From: Amanda Scholes on behalf of Planning.Responses
Sent: 11 March 2020 11:03
To: Planning Scanning
Subject: FW: Planning application LU/48/20/PL. Old Mead Road.

From: carol hatton [REDACTED]
Sent: 07 March 2020 15:19
To: Planning.Responses <Planning.Responses@arun.gov.uk>
Subject: Planning application LU/48/20/PL. Old Mead Road.

Lyminster & Crossbush Parish Council objects to this planning application on the following grounds:

DRAWING TITLE
Street Scenes

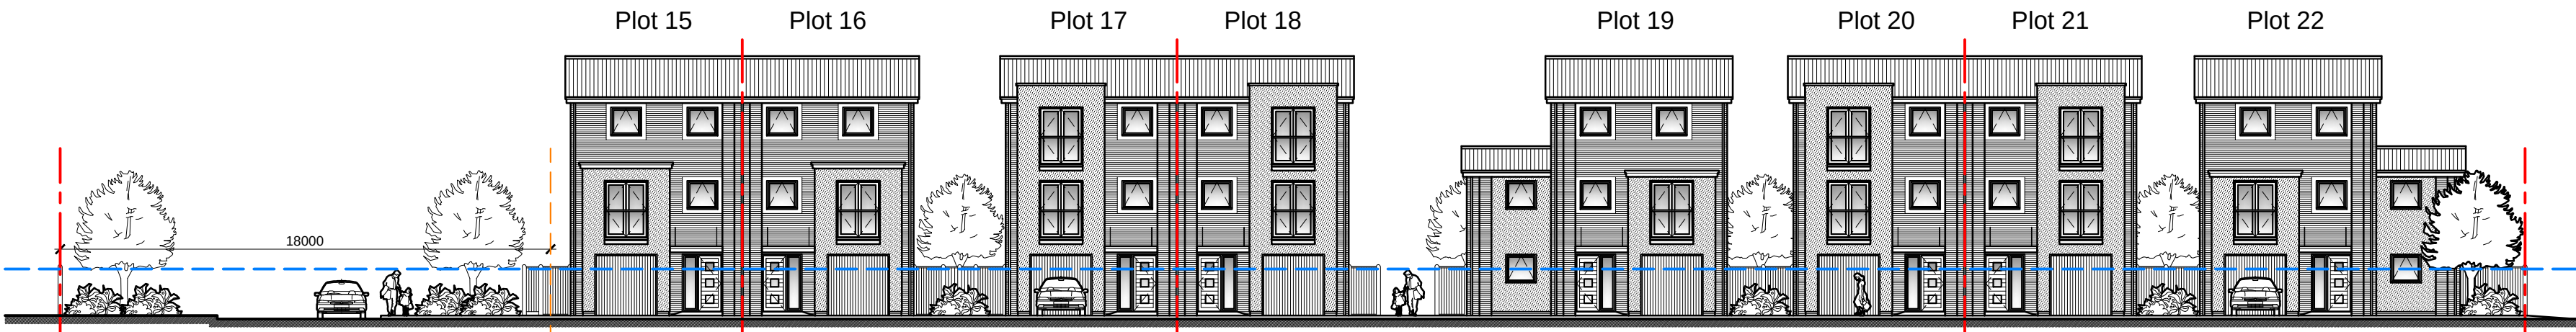
2. The proposed scheme with 3 storey units is in contrast to the surrounding single and low two story development. As proposed the scheme will have unacceptable line of sight impact to the historic town of Arundel and the Lyminster Conservation Area. Lyminster & Crossbush Parish Council envisages further formal consideration of the zone around the Lyminster Conservation Area as part of the current Lyminster & Crossbush Neighbourhood Plan development.
